10th October 2008

New Lodge Crescent, Barnsley – Application ref: 200/1310

Robert Jenkinson
On behalf of Acanthus WSM Architects

Scale: 1:100 / 1:50 @ a2  
 Date: July 2008  
 Drawn: RJJ  
 Dwg No: 2121-015-122C

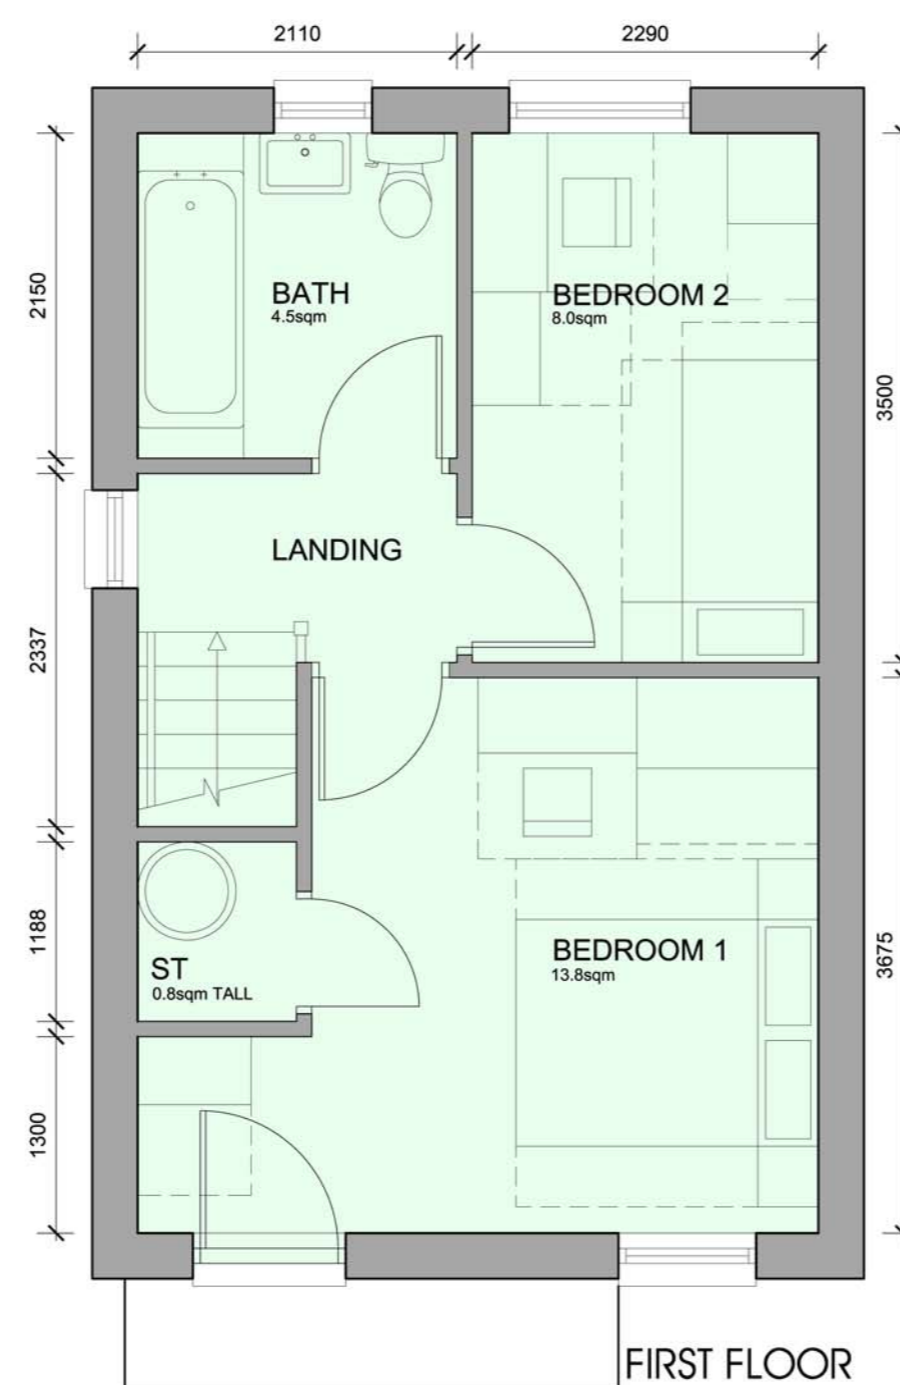
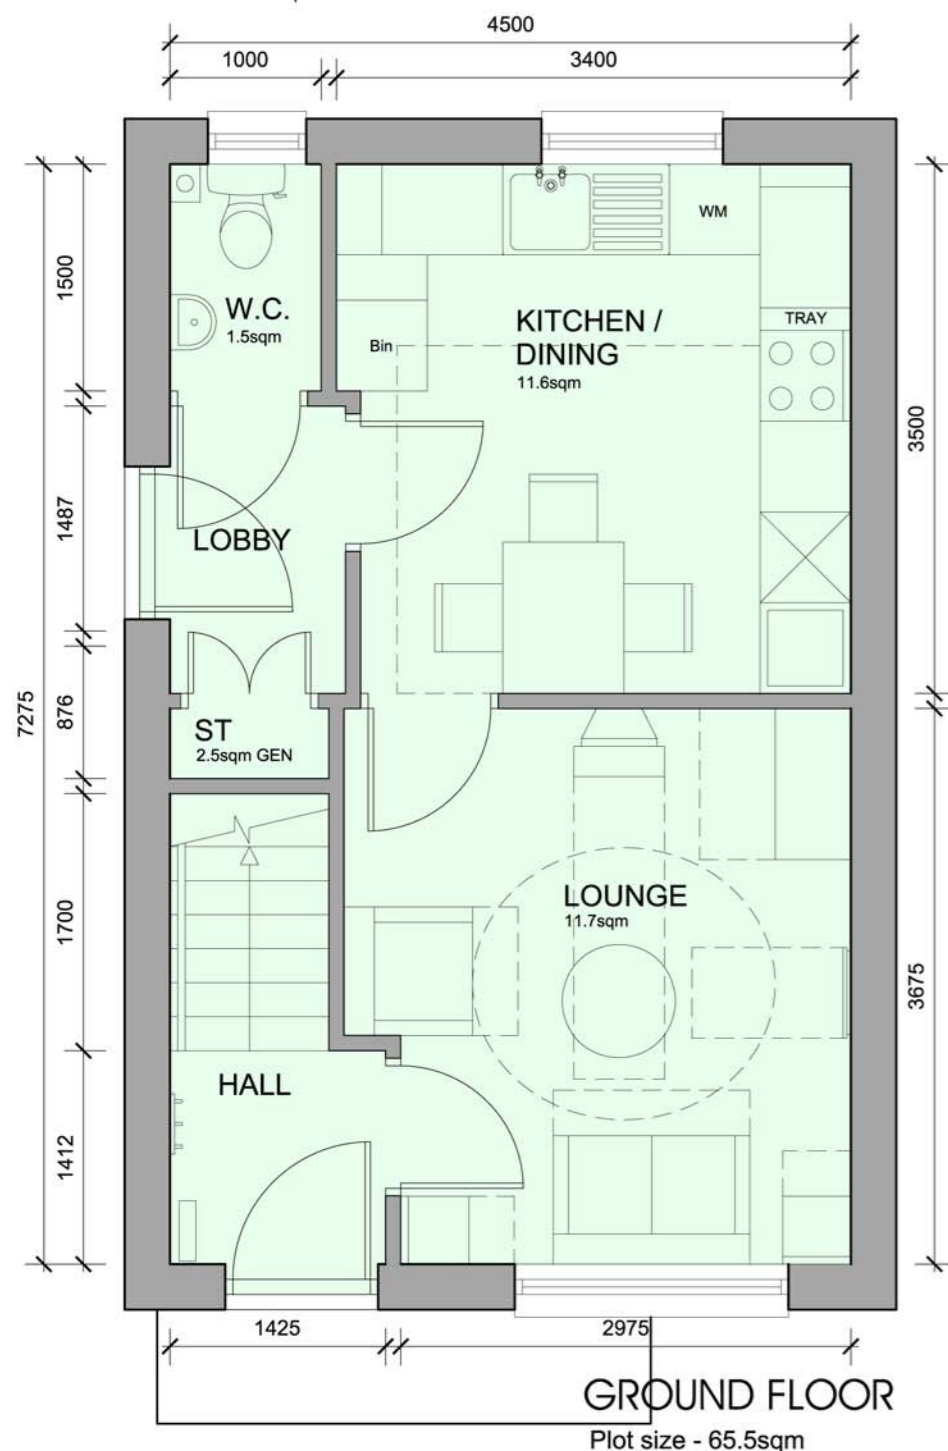
We have also issued further copies of the house type drawings. These have been revised slightly in response to comments made by your design officer regarding the canopy arrangement to some of the units. In response to your officers comments we have also amended the fenestration arrangement to the 3B5P corner unit to simplify the street elevation of this unit.

# Site Sections 3 of 3

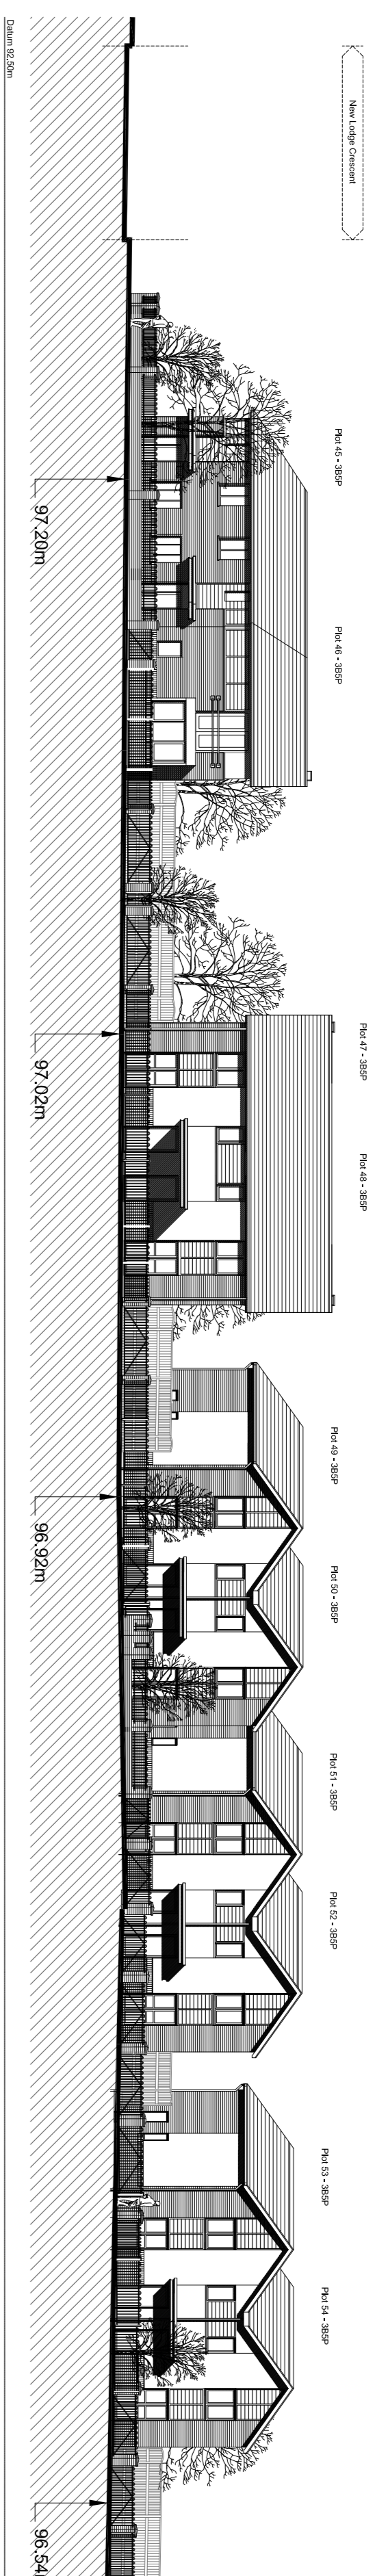
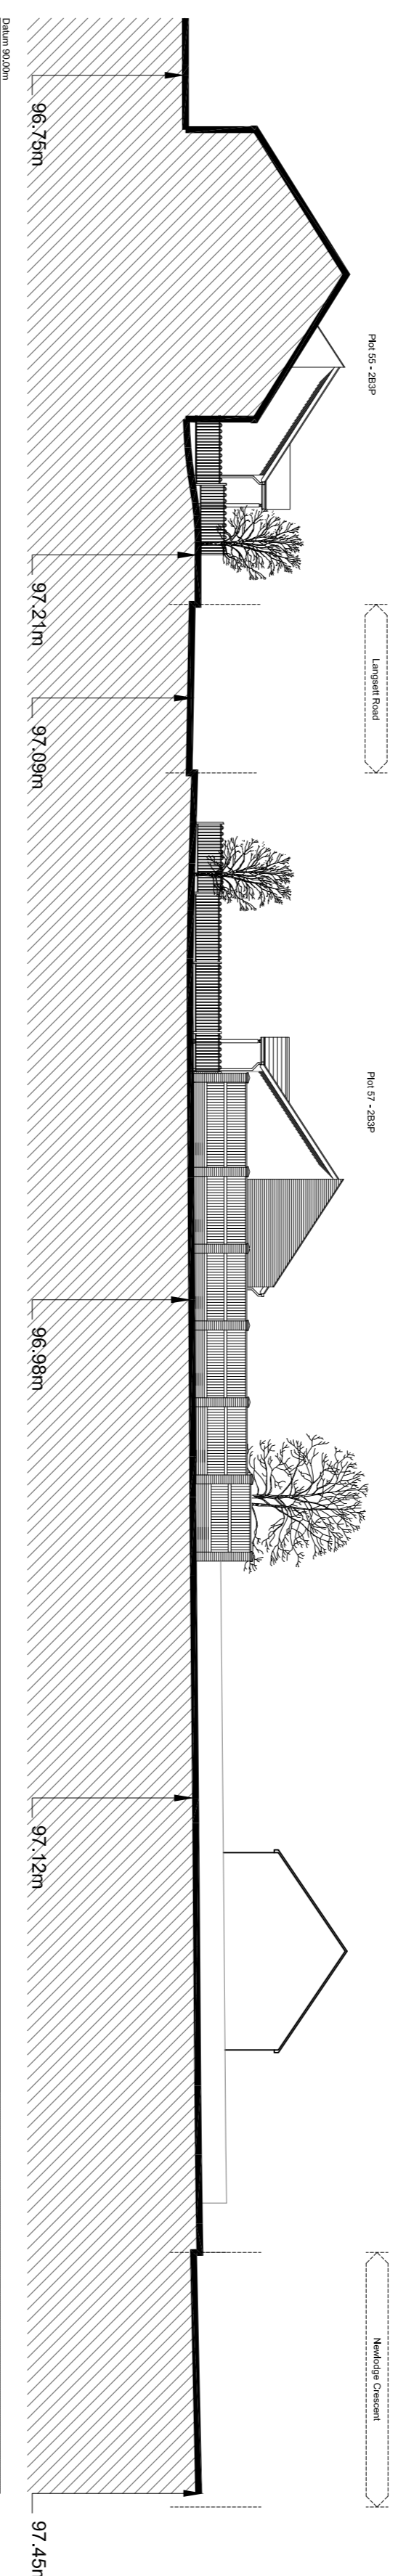
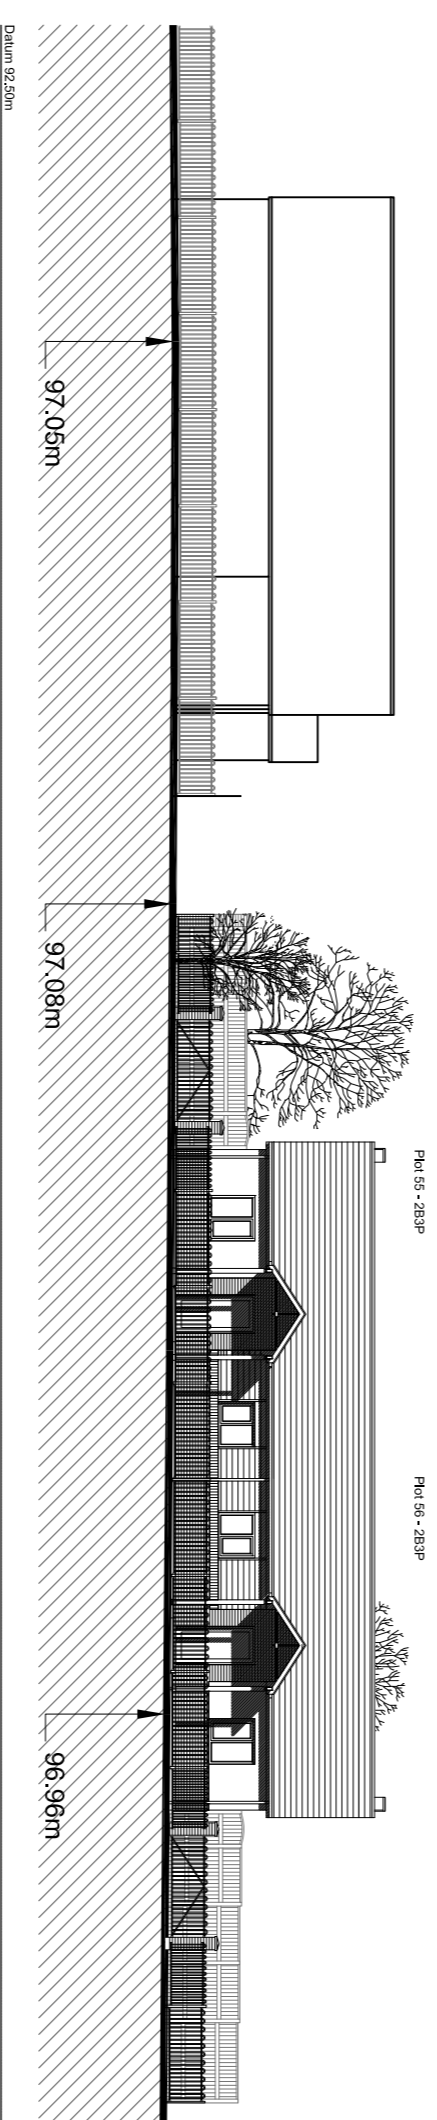
I write further to my letter and email of 3rd October 2008 which accompanied the updated site layout plan for the above development. Today we have issued pdf copies of the revised site section drawings by email. These have been amended to reflect the revisions shown on the current site layout drawing number 2121/15/110D.
